Eastern Creek Business Hub Stage 3 – Meeting with TfNSW on Infrastructure

Meeting Minutes

1. FPA provided an overview of the Eastern Creek site, masterplan and proposed Stage 3 Concept Plan. Noting the planning pathway is 'Amending Concept Plan' with DPIE.

INTERSECTION LAYOUT - TURNING PATHS
SCALE: 1:250@A1

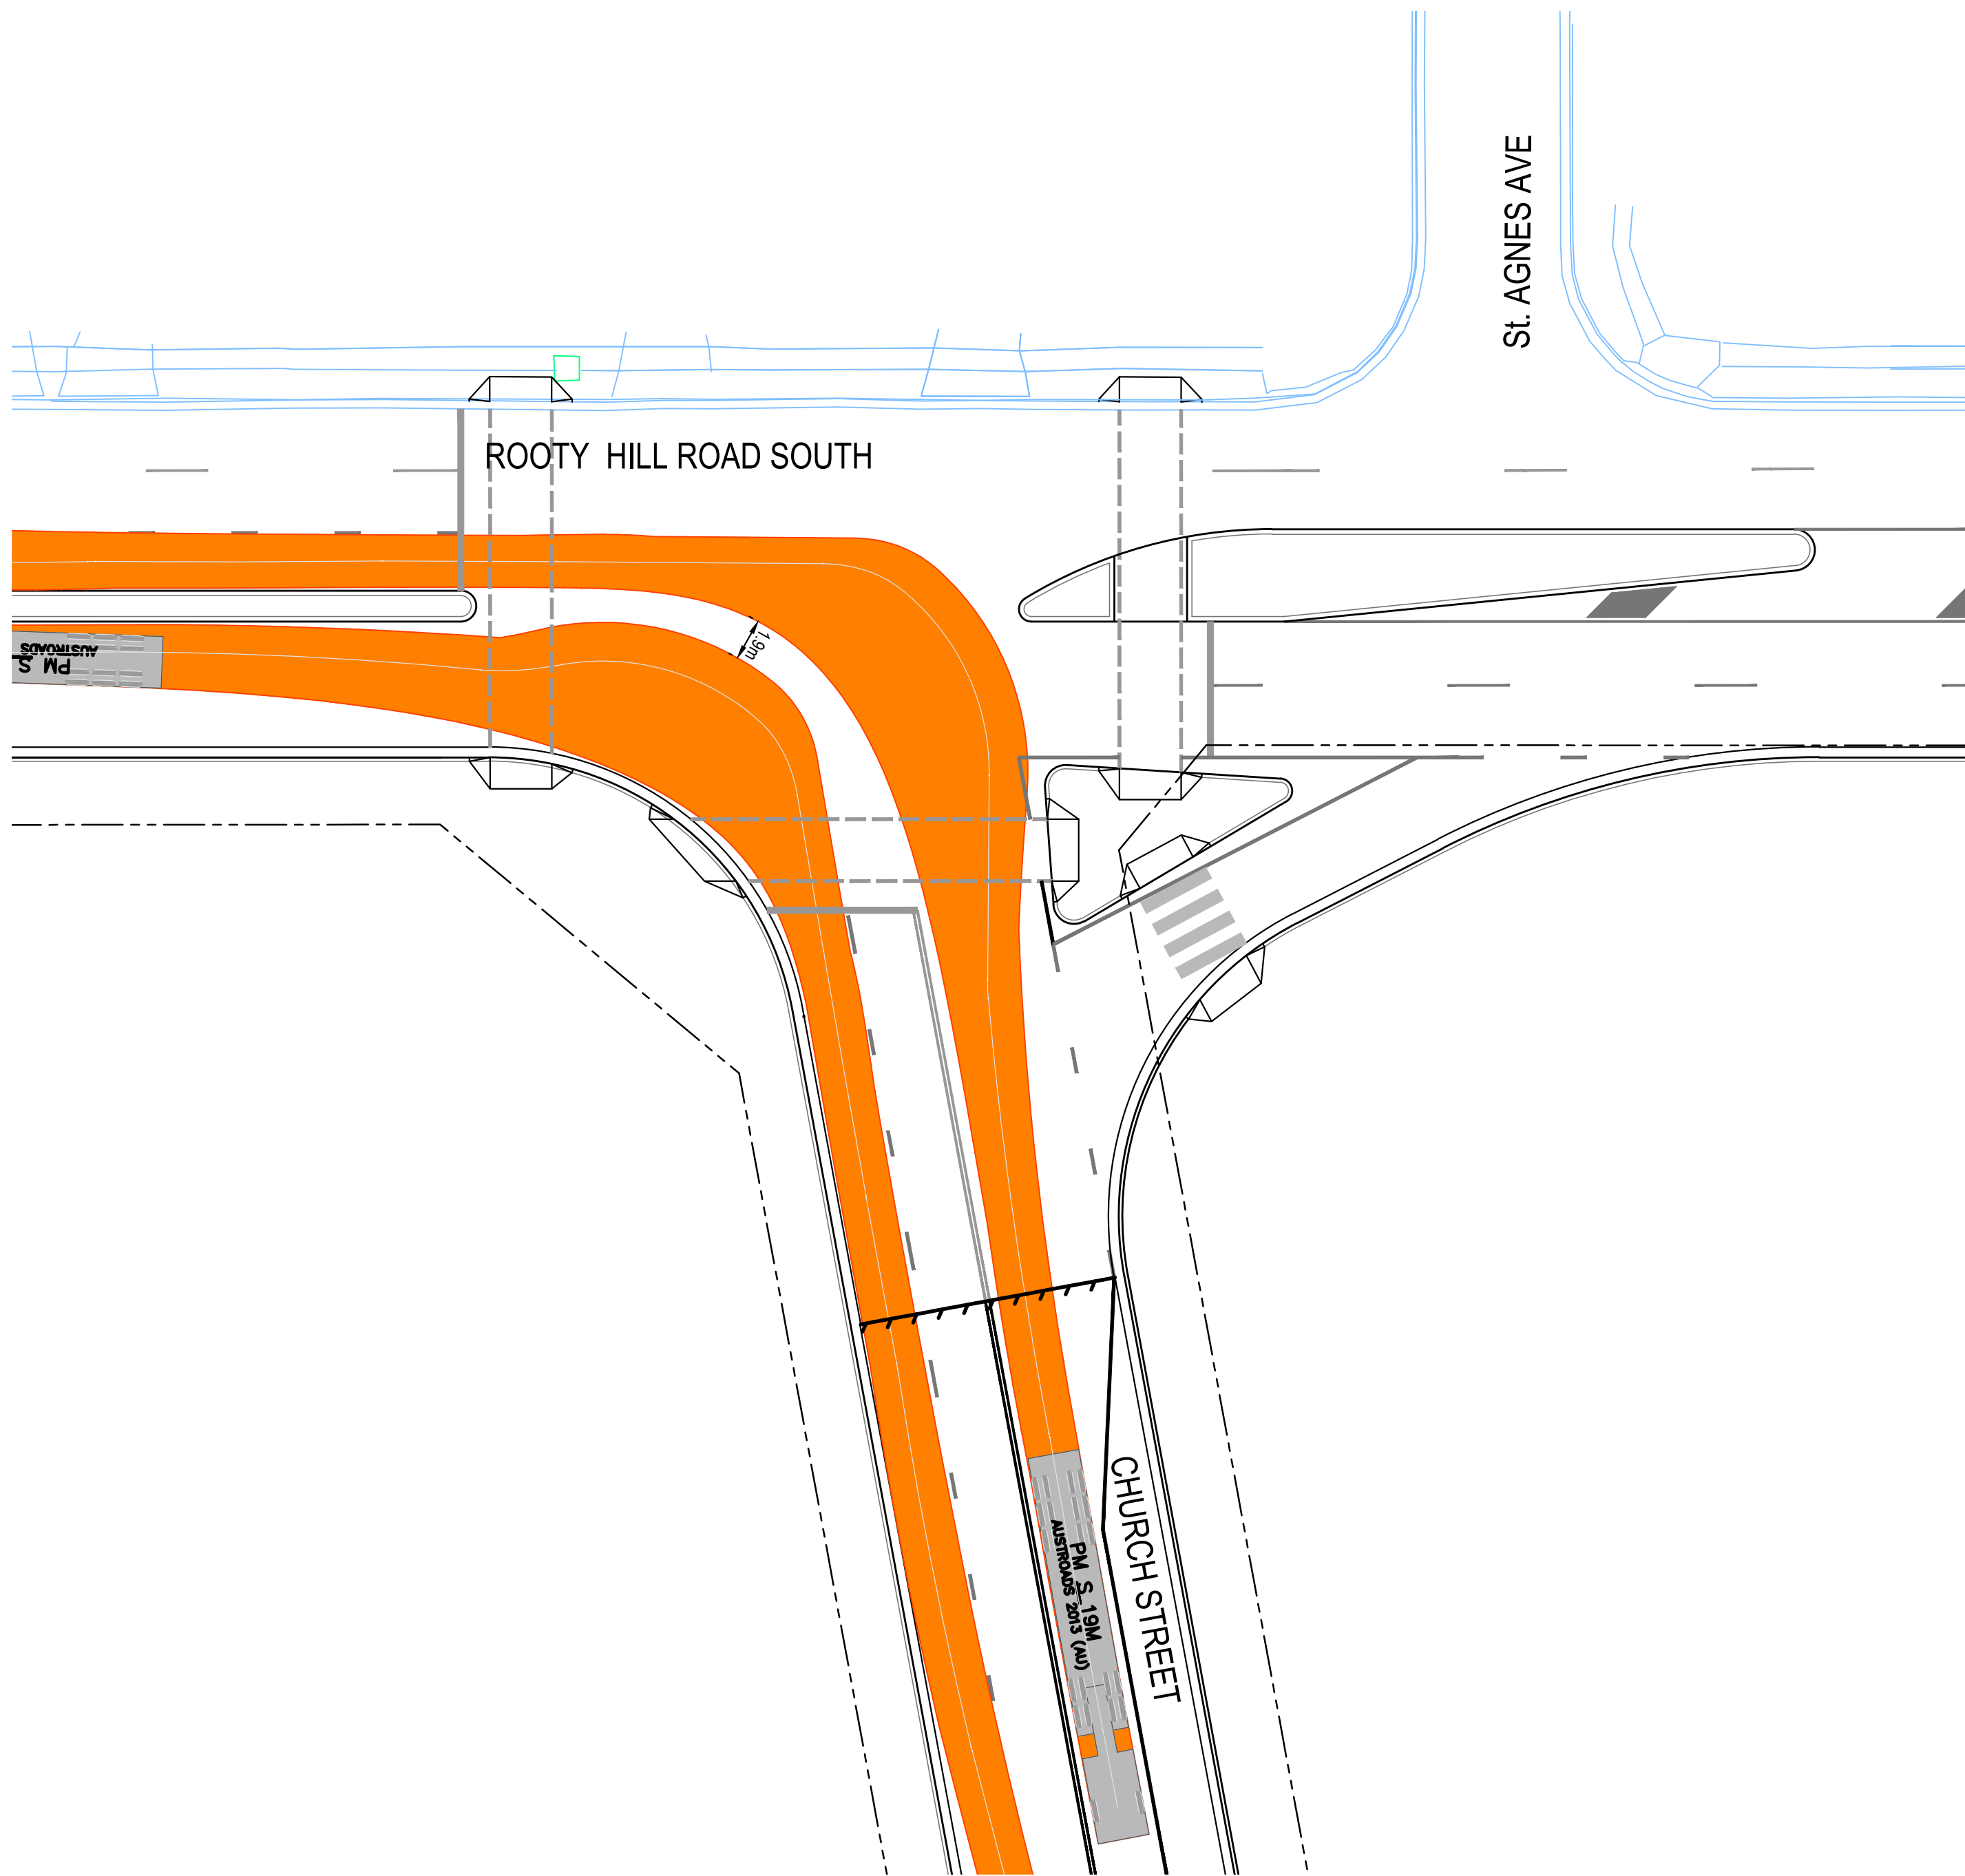
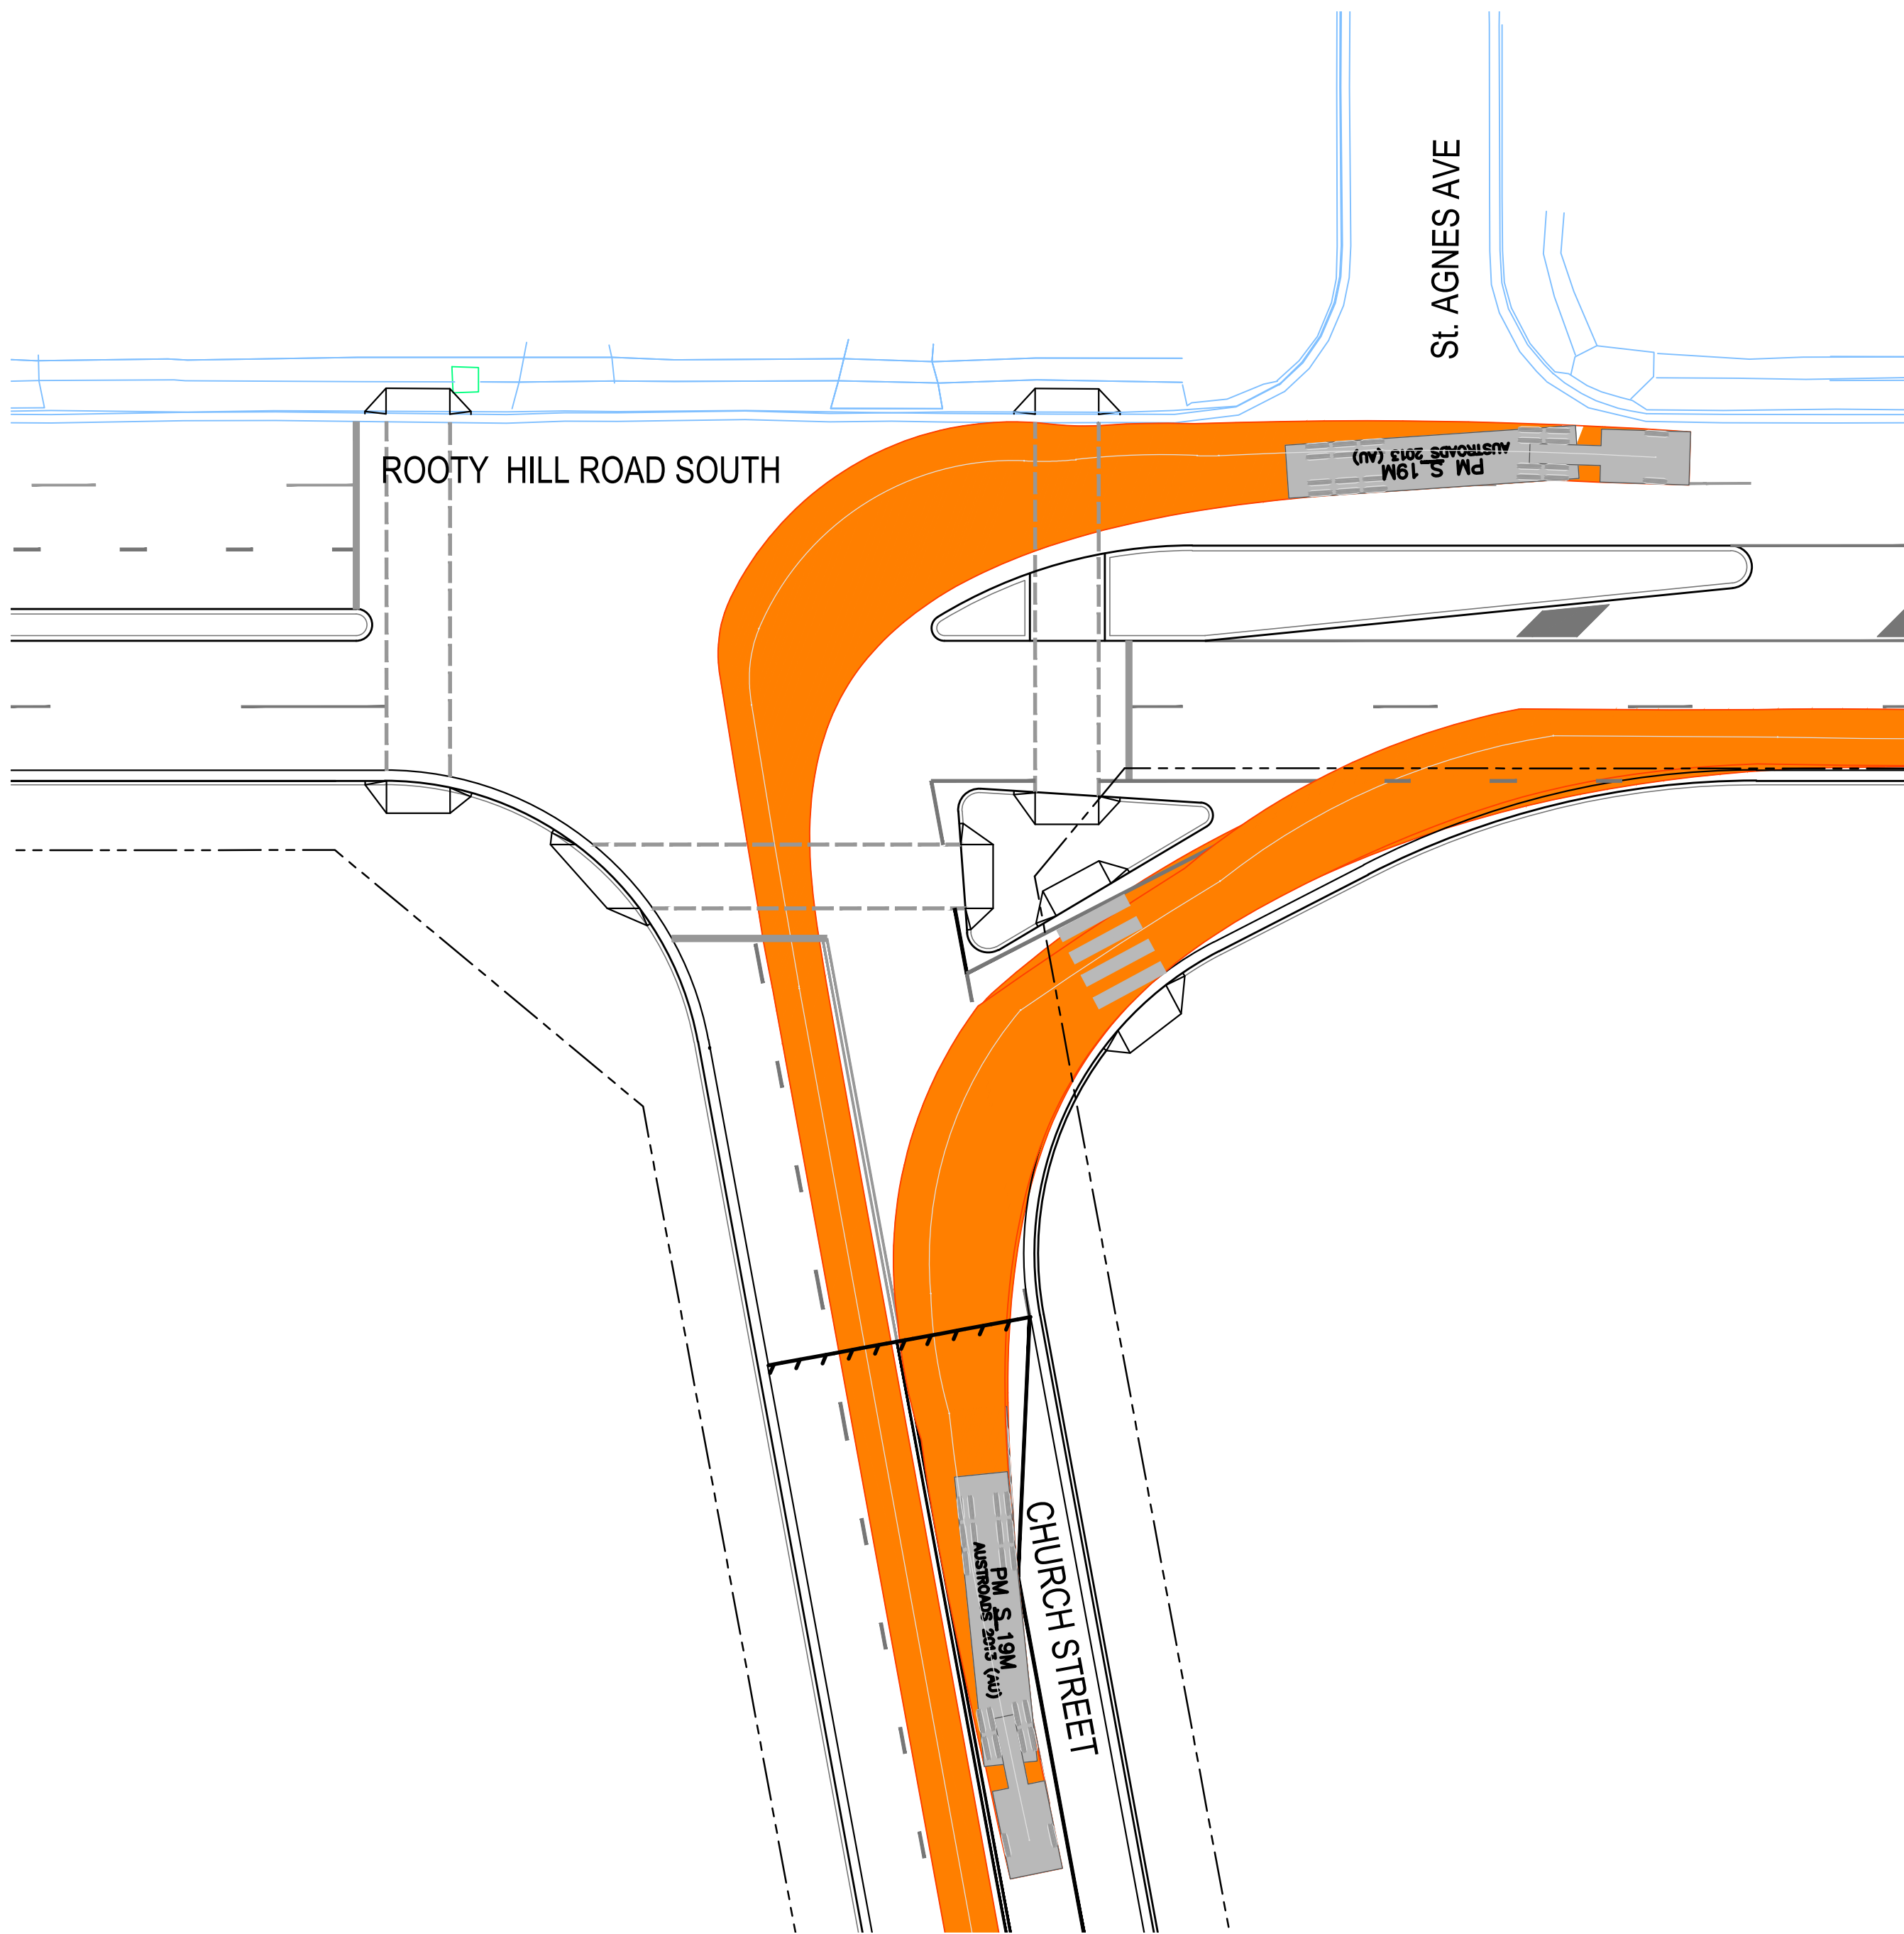
- CBRK proposes that as a mitigating solution, a high angle left turn slip lane to be investigated to reduce the impact of left turning traffic into ECQ Stage 3 on southbound traffic on RHRS.

- 1) FPA / CBRK to update the Church Street/RHRS intersection design to show:
 - a) Single pedestrian crossing;
 - b) A left turn high angle slip lane;
 - c) Median extended to ban right turns to/from St Agnes Avenue & Minchinbury Street.
